From: Iqraa Malik
Sent: 20 July 2020 11:14
To: Sian Eggington
Subject: FW: Request for further information AW/161/20/HH
Attachments: 03-Proposed Plans.pdf; We sent you safe versions of your files

Ivon Blumer Architects Ltd

IVON BLUMER ARCHITECTS LTD			
PROJECT	Wakefield Way	DATE	06/07/19
TITLE	Proposed Plans	DRG NO	IBA/520/03
SCALE	1 : 100	REVISIONS

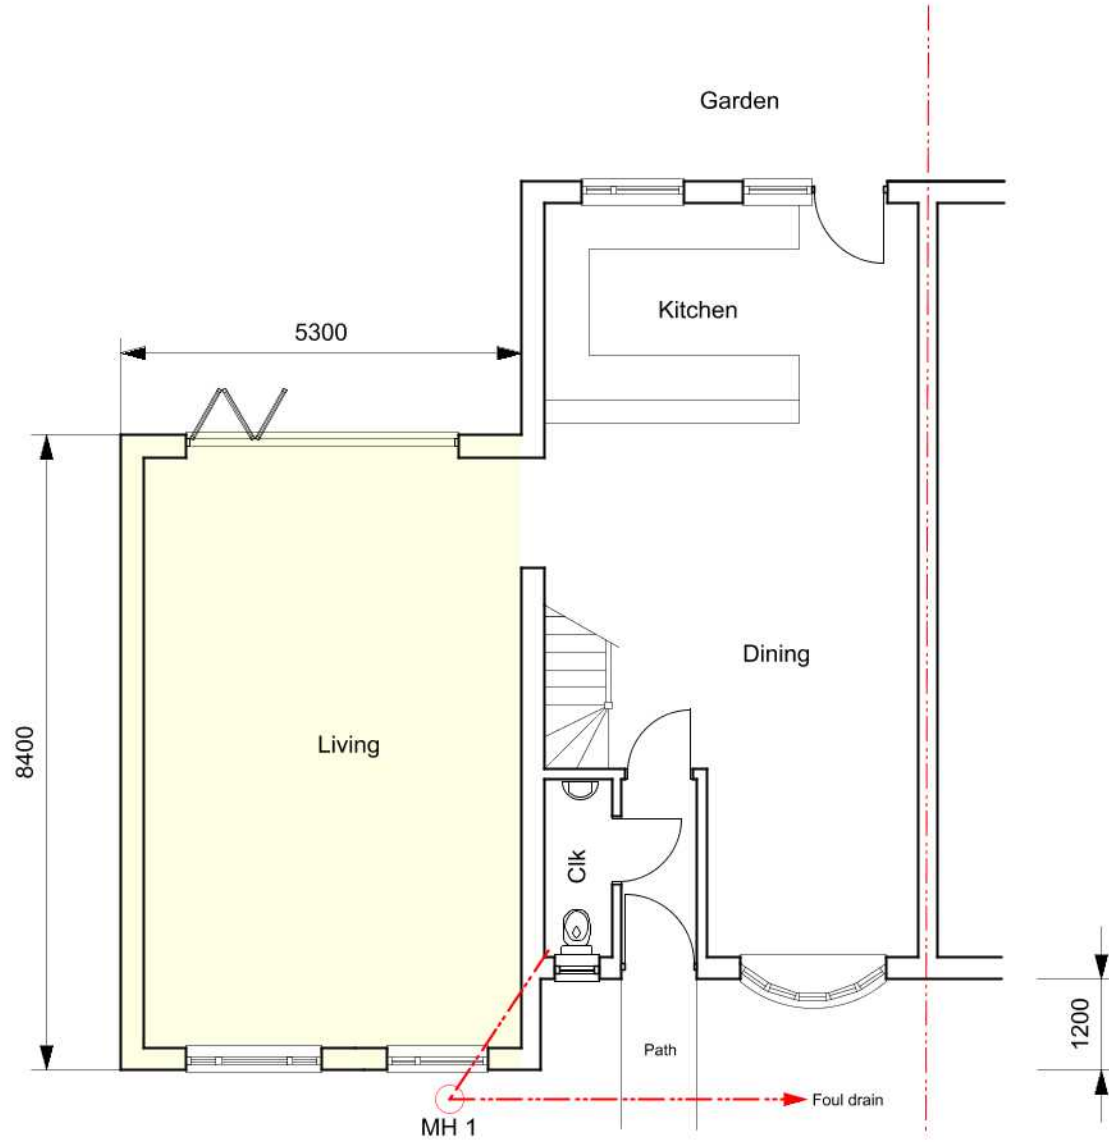
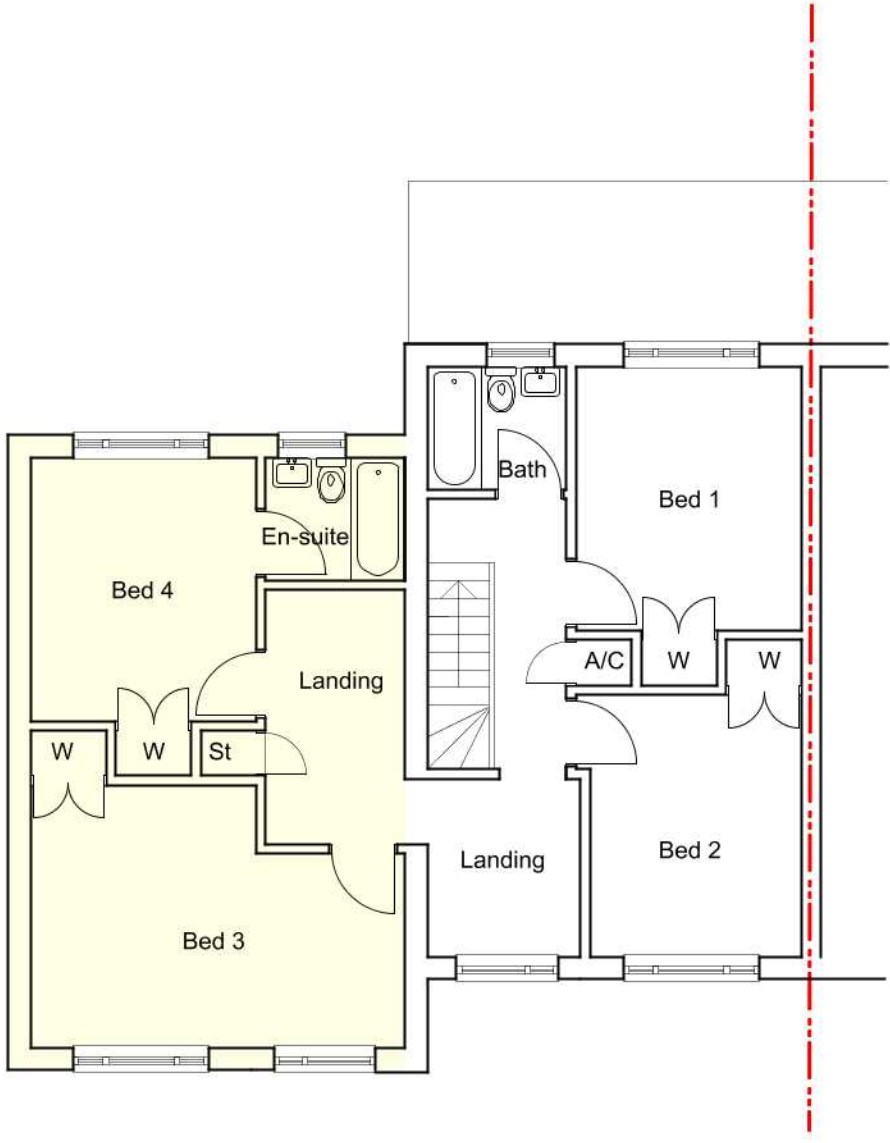
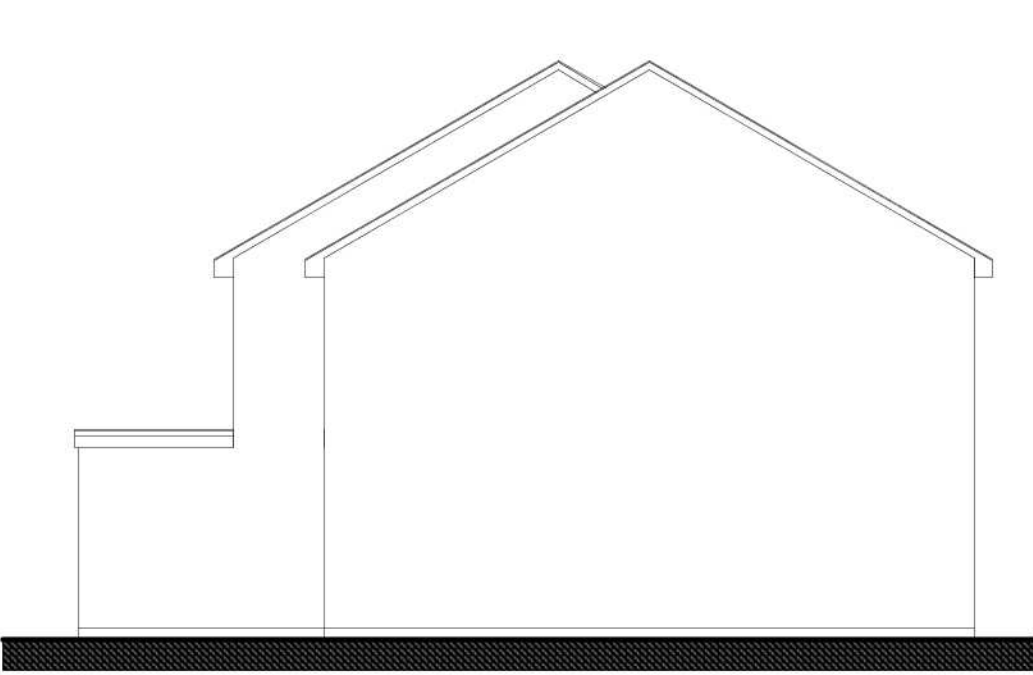
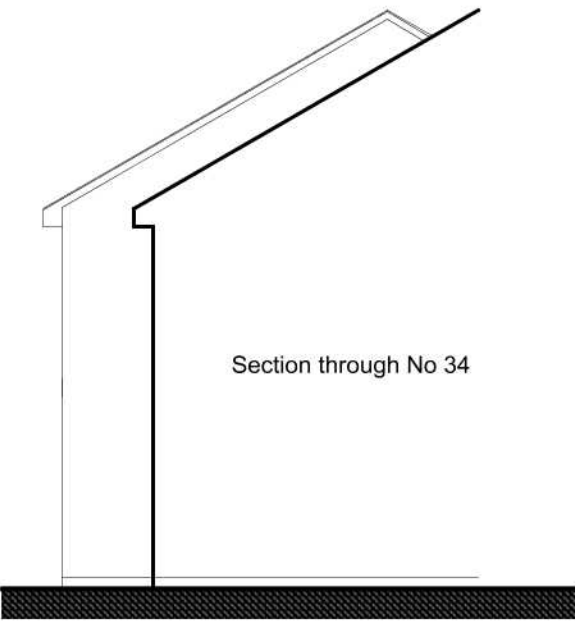
Unfortunately, the building line on the side elevation appears to be inconsistent with the ground floor plan. Please amend or with your permission we are able to amend this for you.

Try this, otherwise I don't know what you mean, happy for you to amend.
